Rockingham Phase 2A – Proposed Commercial Development Reserved Matters
Application Ref: 2021/1007
Response to Comments Made by BMBC Highways dated 9th November 2021
Initial Issue – 29th November 2021
Our Ref: 21095/MOS/TS.

This brief Transport Statement has been prepared to provide a response to the enclosed comments made by BMBC highways following consultation of the Reserved Matters application at Rockingham Phase 2A in support of commercial development.

| Job-Dwg No    | 12006-2 (P)110                                 |              | Rev G |

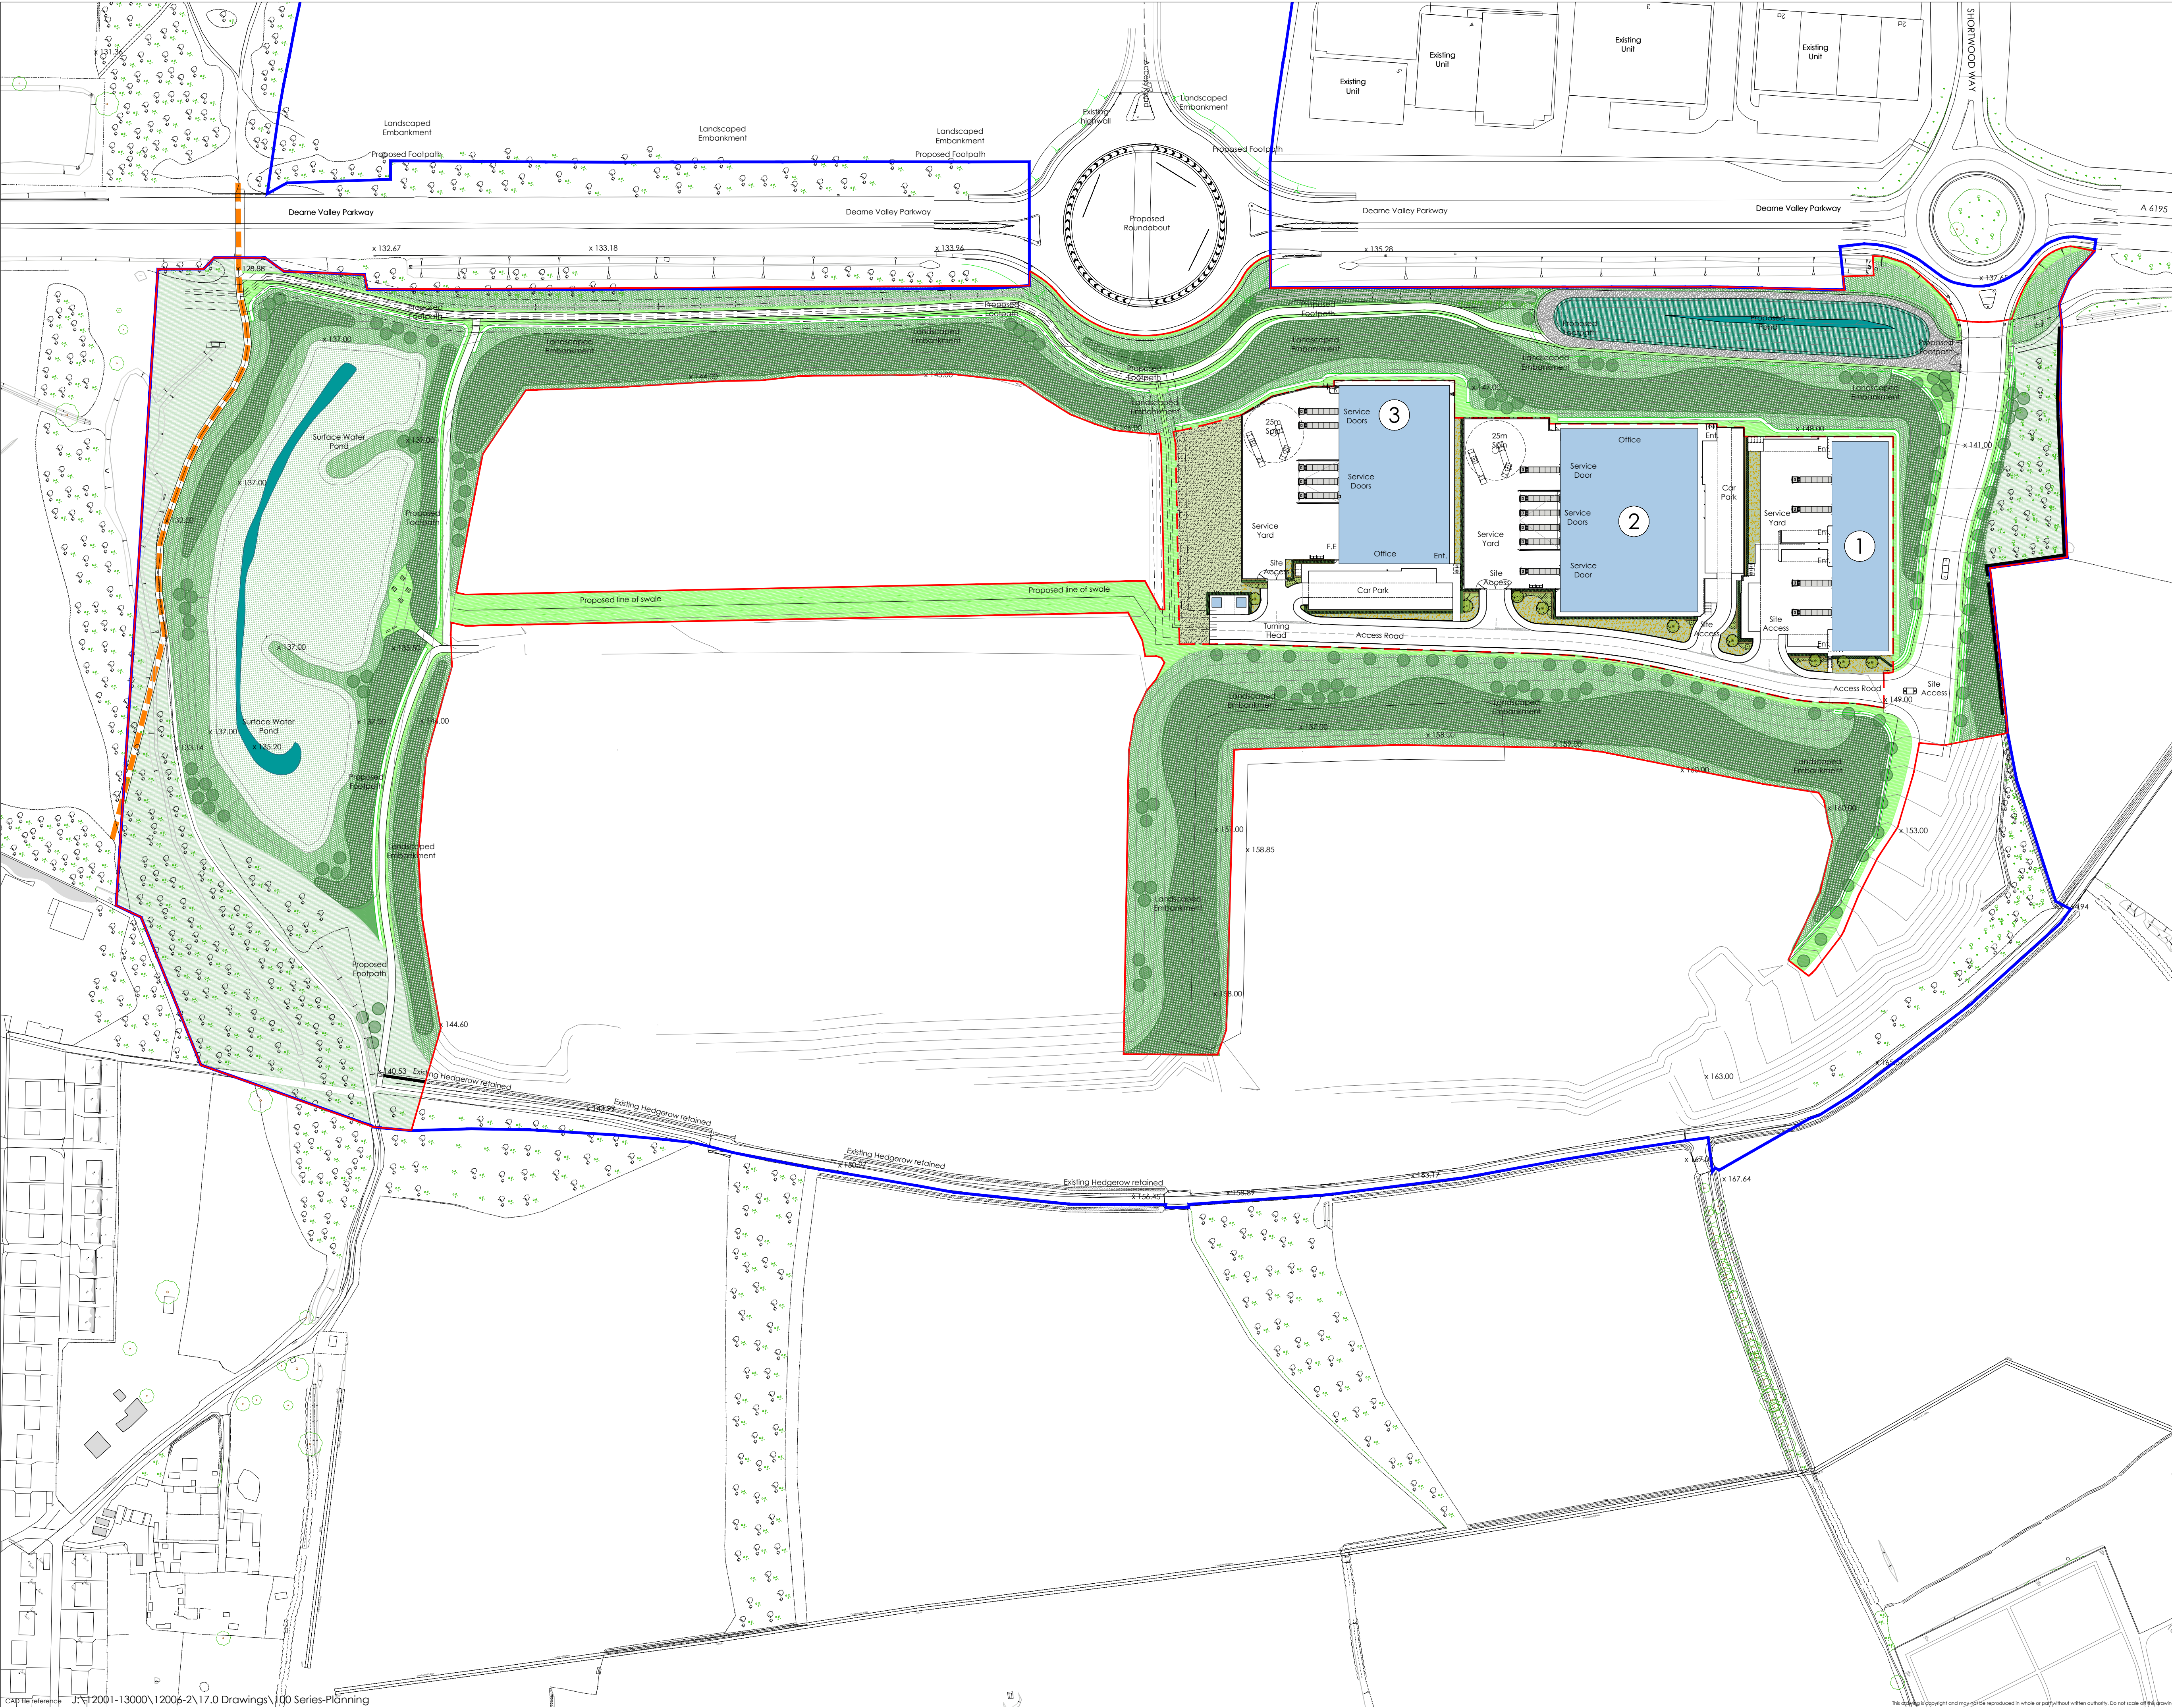
It is acknowledged that the parking that is shown on the enclosed masterplan for Units 2 and 3 exceeds the standards set out for B8 as set out in Barnsley's Parking SPD (adopted 2019).

It is noted that the design and access statement states that car parking accords with the recommendations set out in the BMBC parking SPD with the proposed spaces and recommended spaces contained within the table in Section 5.3. The parking allowance for units 1A to 1D have been calculated based on B1c / B2 use and B8 use for units 2 and 3. However checks on the recommended requirements within the table for B8 does not appear to accord with the standards and therefore clarification is required to demonstrate the proposed number of spaces accords with the standard below:

However, the parking has been set at a level that reflects what is demanded by tenants and is appropriate for the use class when consideration is given to the expected number of staff that work at B8 commercial development.

It can be seen that Unit 2 has 7 additional spaces and that Unit 3 has an additional 9 spaces when combining standard and disabled parking spaces.
